From: PETER SHAW [REDACTED]
Sent: 16 April 2025 13:04
To: Harry Chalk <Harry.Chalk@arun.gov.uk>
[REDACTED]
Subject: Re: RE: RE: RE: RE: 31 Aldwick Road BR/32/25/PL

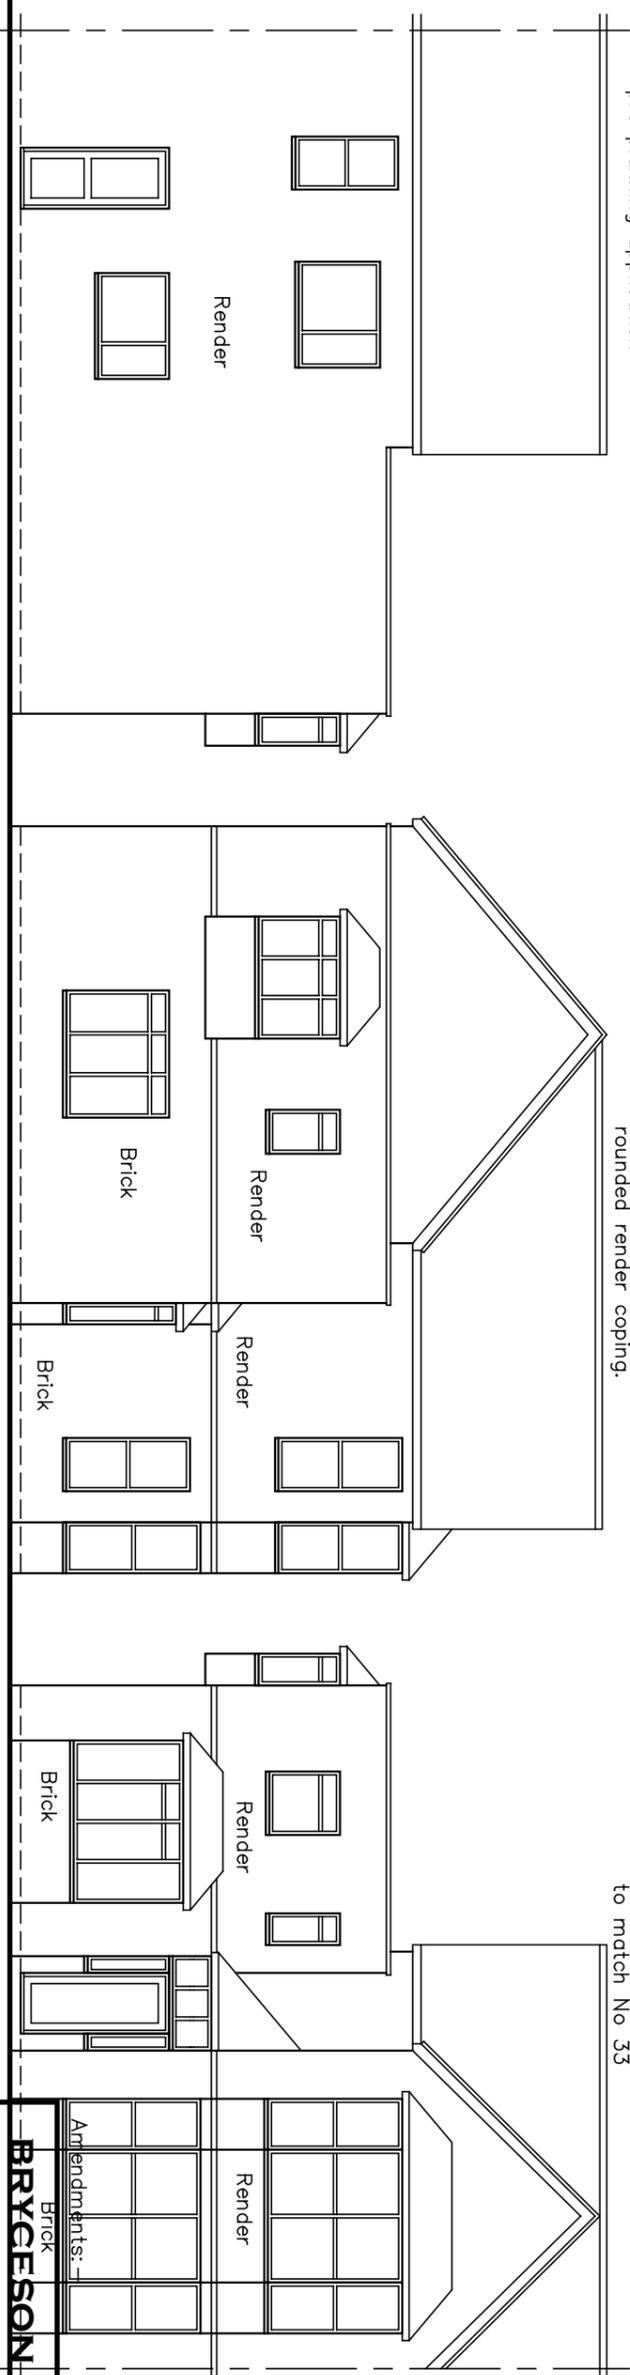
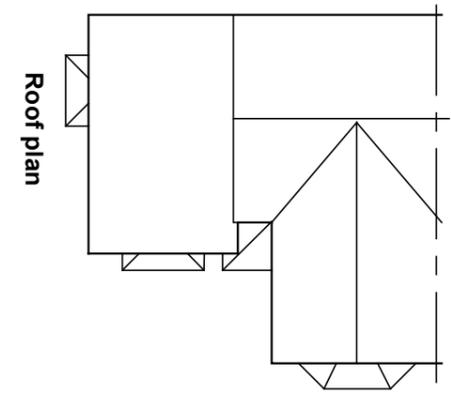
The CAAP point out that the note on the left of the plans is ambiguous, implying that fascia and soffits etc are to be UPVC. From my reading of this note, it states that fenestrations (windows) will be white UPVC vertical sash style, and that facias, soffits and gutters etc. are to match existing. I think the wording/grammar could have been a bit clearer, but could you confirm my interpretation is correct? That windows are to be white UPVC vertical sash, and that the fascia, soffits, and gutters are to match the existing?

Could I ask that the plans/elevations be amended to reflect this please? Could I also ask that the proposed elevations be annotated to show where the brickwork and render will remain following the repairs? I understand this will match the existing elevations, but it would be helpful for context.

Yes I confirm your interpretation.

See revised attached. The side wall is now flint and the front wall rendered brick matching No. 33.
